**Application by Highways England for M54 to M6 Link Road**  
**Statement of Final Position in respect of matters examined**  
**Deadline 9 - 16<sup>h</sup> April 2021**  
**Allow Ltd (Allow)**

FIGURE 2.6
DRAFT ENVIRONMENTAL
MASTERPLAN
SHEET 4 OF 5

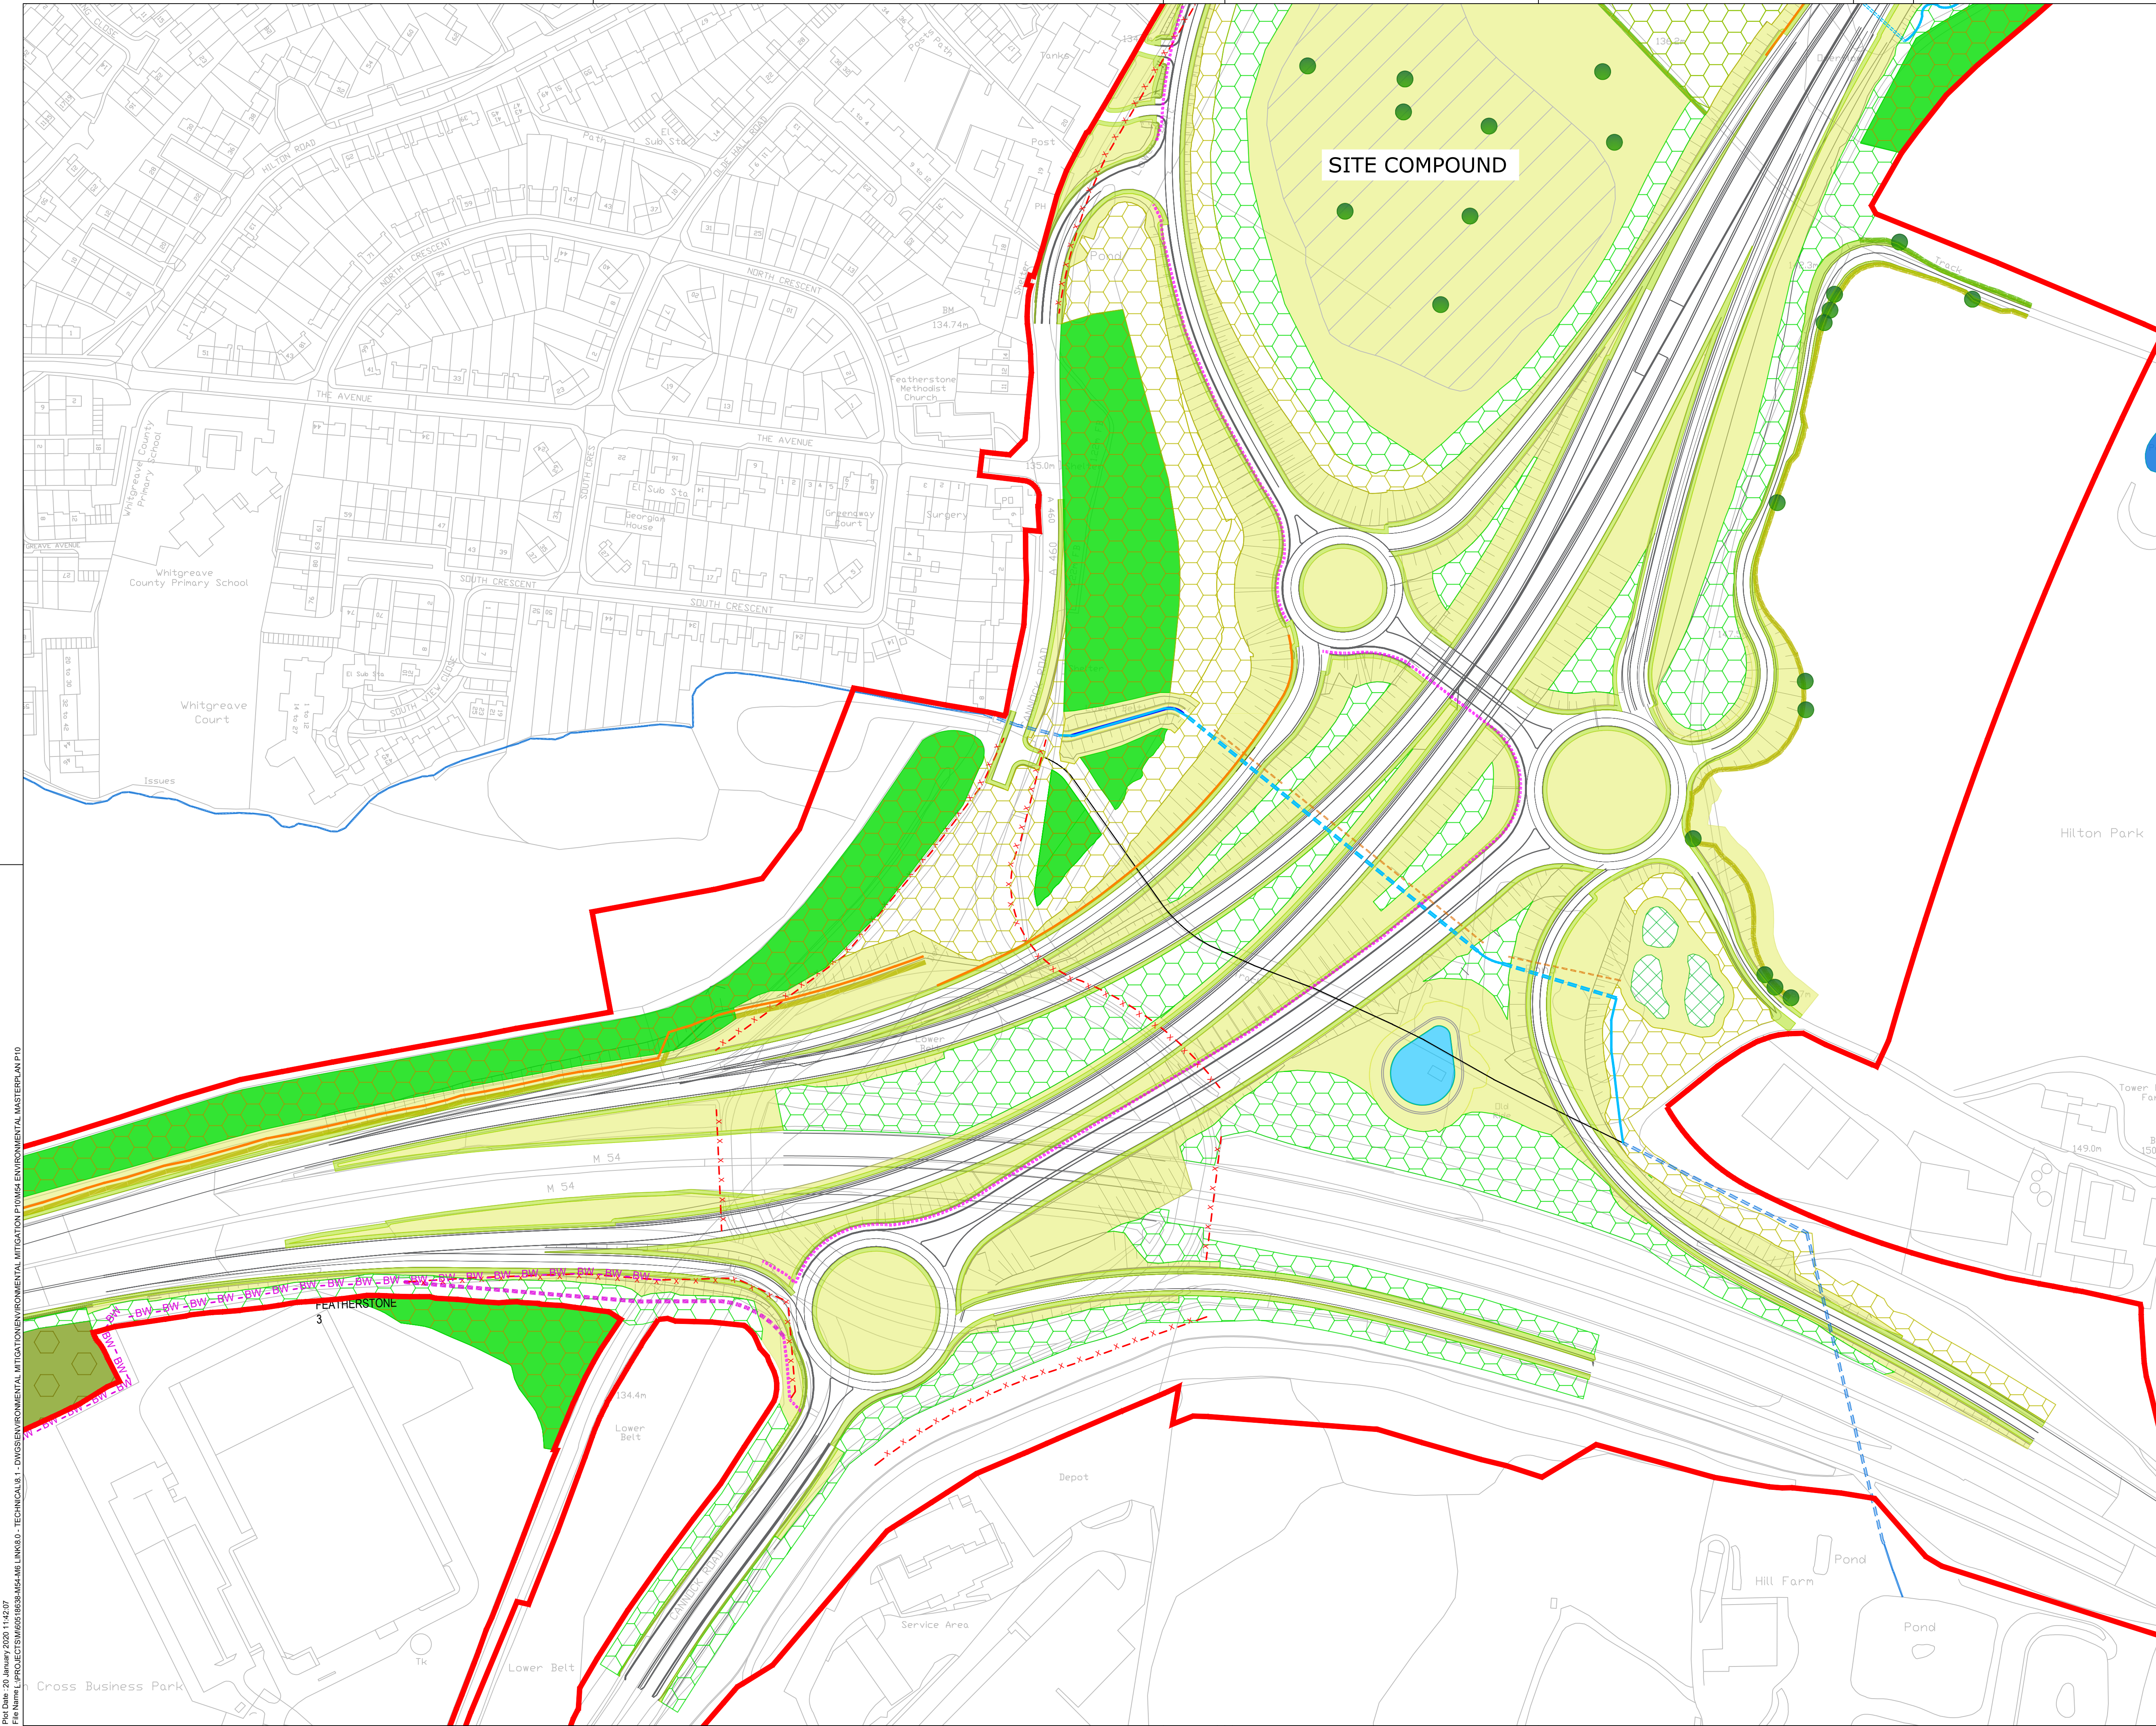
5. The key issue for the Examining Authority to note relates to Allow's position that the proposed planting design to the east (Allow Option) is a more favourable location to achieve the best balance of the environmental and historical considerations. The Applicant has been unyielding in their position that they will not consider any form of planting to the east despite clear evidence of considerable ecological benefits, which will not be achieved if the Applicant's proposed position is adopted. The Applicant has failed to take on board the ability for Allow to make alterations to the unprotected parkland landscape as it wishes at any time and Allow's willingness to be receptive to landscape design suggestions.

6. In respect of the environmental mitigation which is proposed for plot 5/2, Allow's submissions at the Compulsory Acquisition Hearing on 10<sup>th</sup> December demonstrated that neither the relevant legal nor the policy tests have been met in respect of that land.

8. Allow understands the need for environmental mitigation of the scheme but considers the extent of the environmental mitigation to be excessive. An example of unclear and inconsistent information is that the mitigation woodland planting proposed at 5/2 is stated as 4.84 ha (TN 8.20) to mitigate against losses of 2.57 ha at Lower Pool. However, the mitigation proposed extends to 4.945 ha at 5/2, plus 0.384 ha adjoining the motorway (East) at Lower Pool (5/4 & 4/20c), plus 0.95 ha of woodland screening at 4/20c. This totals 6.28 ha and the latter two areas do not seem to have been taken into consideration for the mitigation of Lower Pool woodland whilst actually being in closer proximity thereto than 5/2.
